Our ref: DOC19/1007923

Subject: Comments on Environmental Impact Statement for mixed use towers – Site 2A and 2B – SSD 9383 – corner Murray Rose Avenue and Australia Avenue, Sydney Olympic Park

Subject: EES comments on the Environmental Impact Statement for mixed use towers – Site 2A and 2B– SSD-9383 – corner Murray Rose Avenue and Australia Avenue, Sydney Olympic Park

ARCADIA
LANDSCAPE ARCHITECTURE

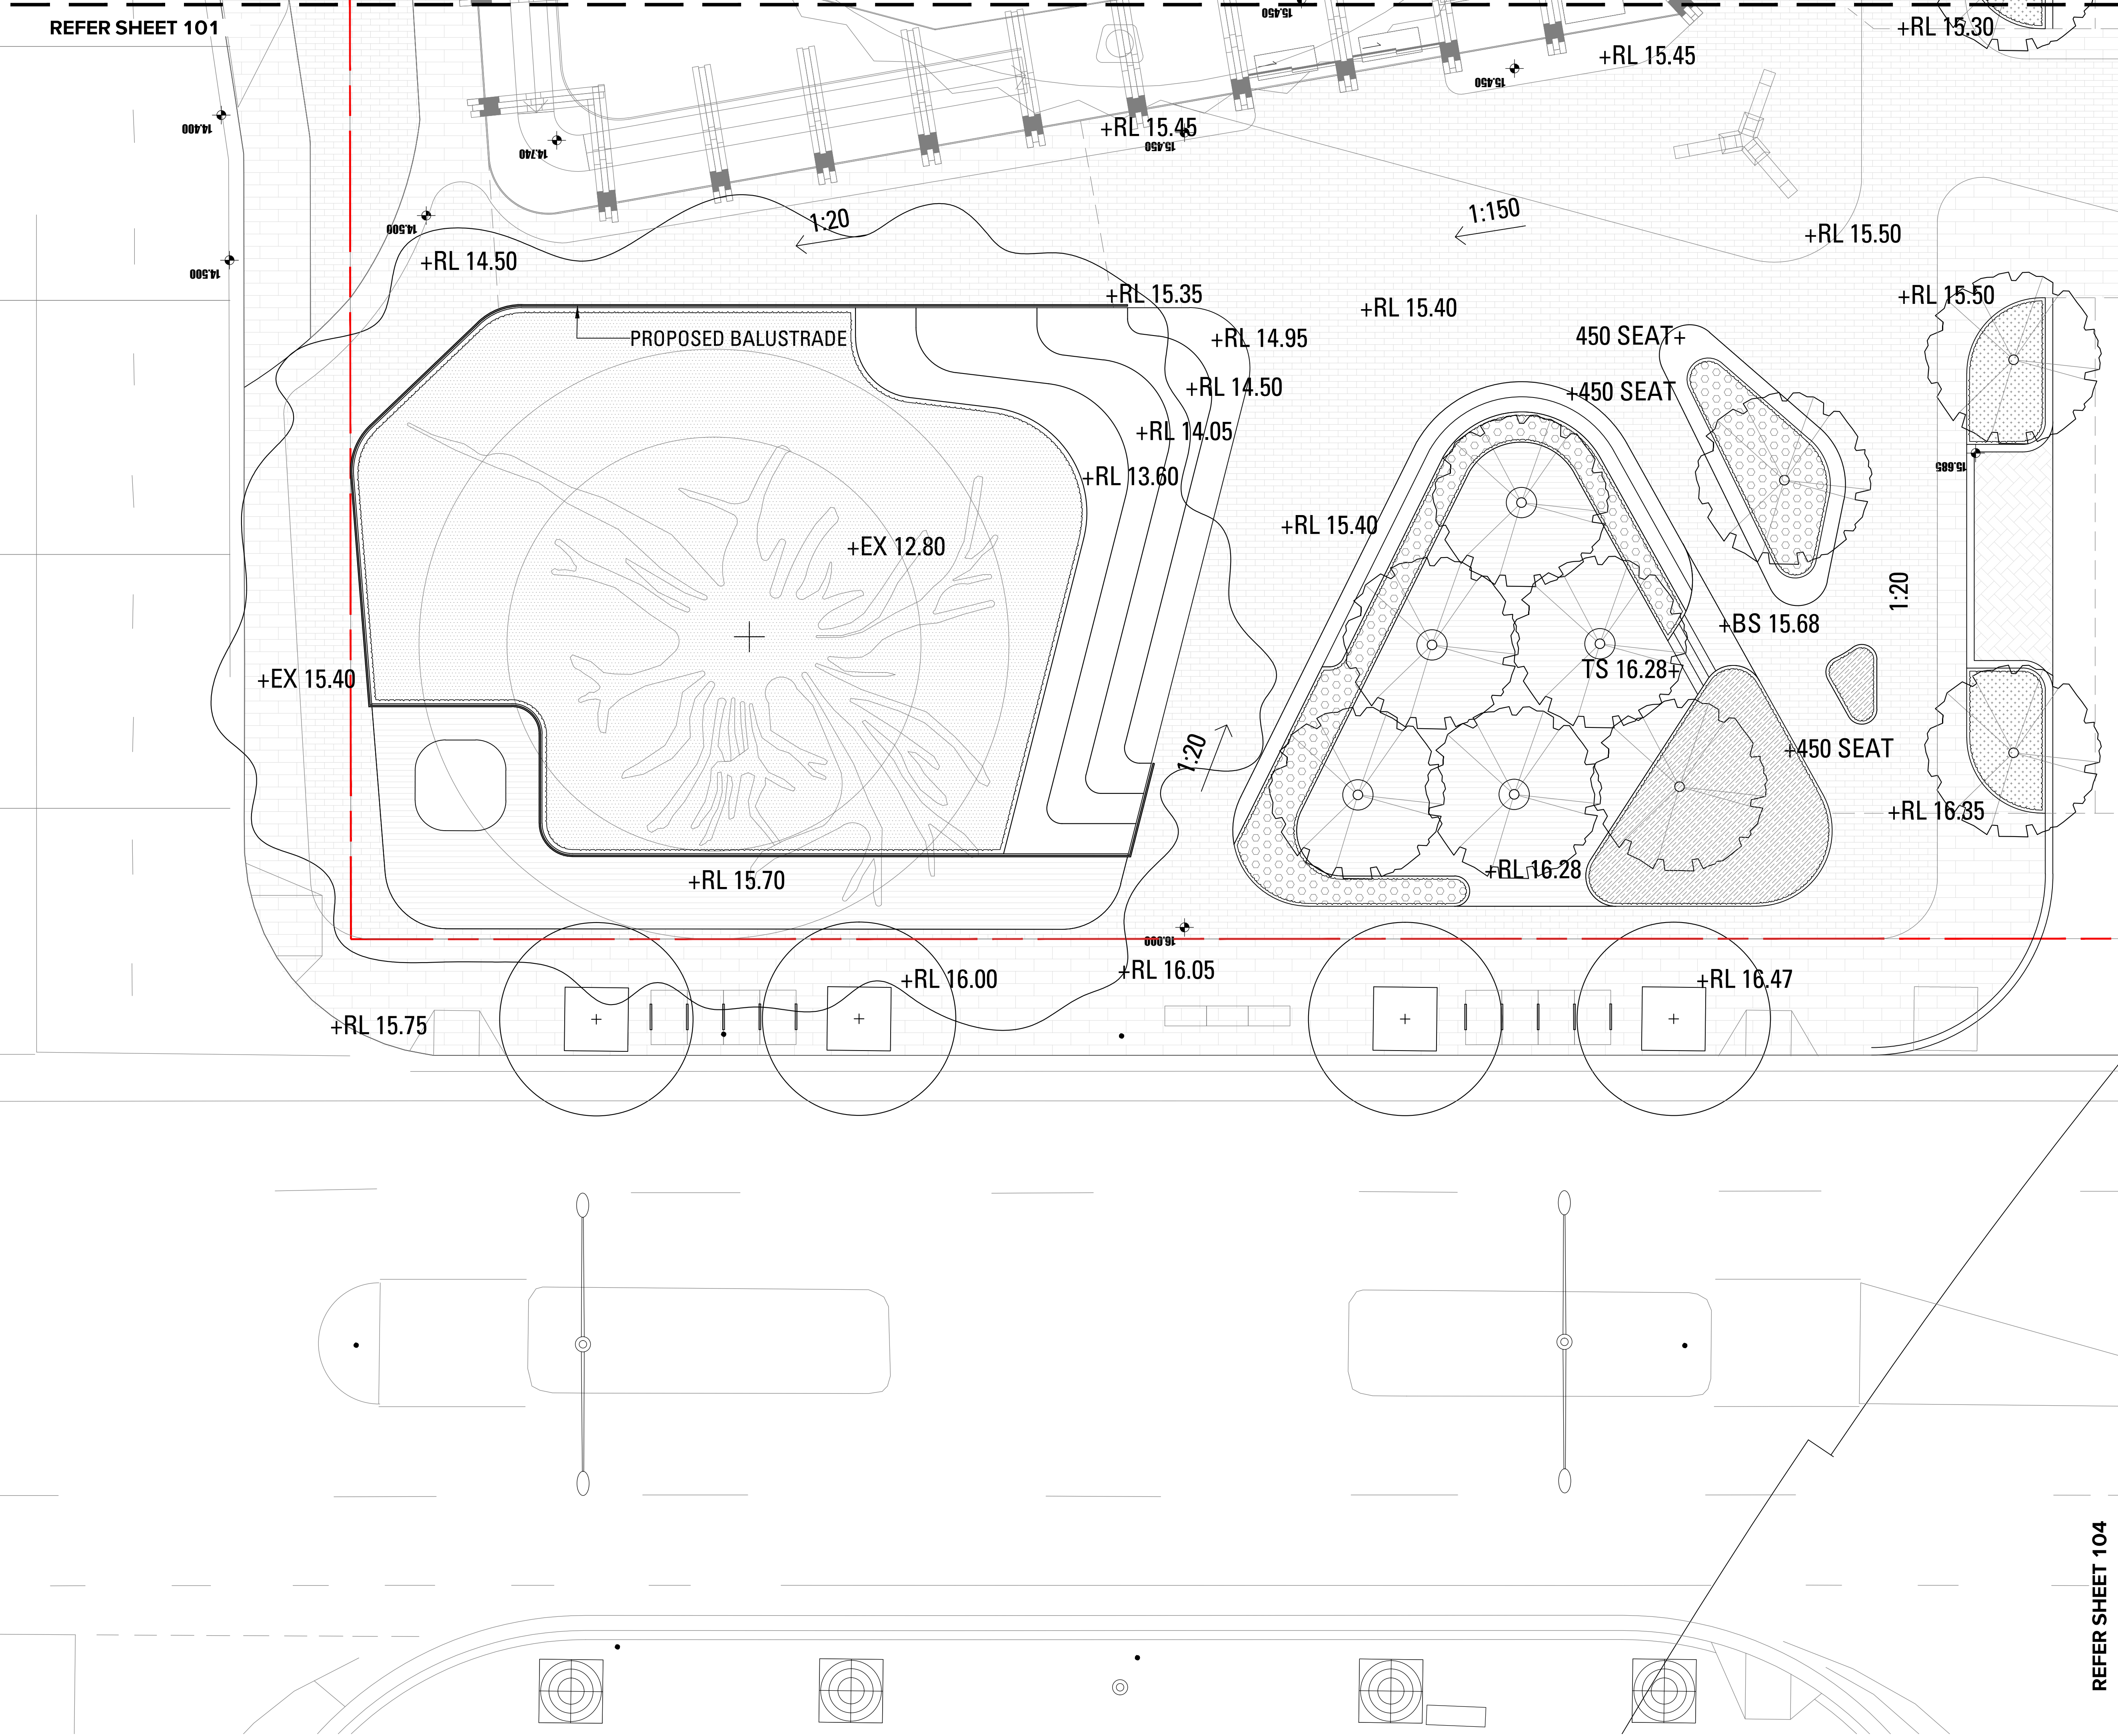
The EIS has not addressed these SEARs. The EIS notes the proposed development will provide landscaping with similar planted species to what currently exist on the site which is urban native/exotic vegetation (page 93). The existing plants on the site are not local natives, for example, the street trees include a mix of species native to NSW, but they are not endemic to the locality (Section 3.2, page 7 of EA).

The EIS includes a mitigation measure for biodiversity that “vegetation to be removed during construction will be replaced with new planting in landscape areas” (page 102) but it does not specify that local native plant species are to be used.

- landscaping at the site be consistent with the SEARs and uses a diversity of local provenance native species from the native vegetation community that would have once occurred in this locality, rather than use exotic species and non-locally occurring native species
- the mitigation measure and the Planting Palette in the Landscape Development Application are amended, and a condition of consent is included which requires the SSD to use local native provenance species from the relevant local native vegetation community which once occurred in this locality
- the RTS provides information to demonstrate the developments consistency with the SEARs.

The EIS indicates the SSD requires the removal of 15 trees on the site (page 44). To mitigate the urban heat island effect and improve the urban tree canopy and local habitat EES recommends that the development:

- replaces any removed trees at a ratio greater than 1:1
- uses advanced and established trees preferably with a minimum plant container pot size of 75-100 litres, or greater for local native tree species which are commercially available. Other local native tree species which are not commercially available may be sourced as juvenile sized trees or pre-grown from provenance seed
- provides enough area/space to allow the trees to grow to maturity.

1. The landscaping at the site shall use a diversity of local native provenance trees, shrubs and groundcover species (rather than exotic species or non-local native species) from the relevant native vegetation community which once occurred in this locality.

2. Trees removed, shall be replaced at a ratio greater than 1:1,
3. Enough area/space is provided on site to allow the trees to grow to maturity.
4. Tree planting at the site shall use advanced and established trees with a minimum plant container pot size of 75-100 litres, or greater for local native tree species which are commercially available. Other local native tree species which are not commercially available may be sourced as juvenile sized trees or pre-grown from provenance seed.

5. The Landscape Plan shall include details on:
 - a) the native vegetation community that occur or once occurred in this locality
 - b) a list of local provenance tree, shrub and groundcovers to be used in the landscaping

- c) the quantity and location of plantings
 - d) the pot size of the local native trees to be planted
 - e) the area/space required to allow the planted trees to grow to maturity

- f) Plant maintenance. The planted vegetation should be regularly maintained and watered for 12 months following planting. Should any plant loss occur during the maintenance period the plants should be replaced by the same plant species.
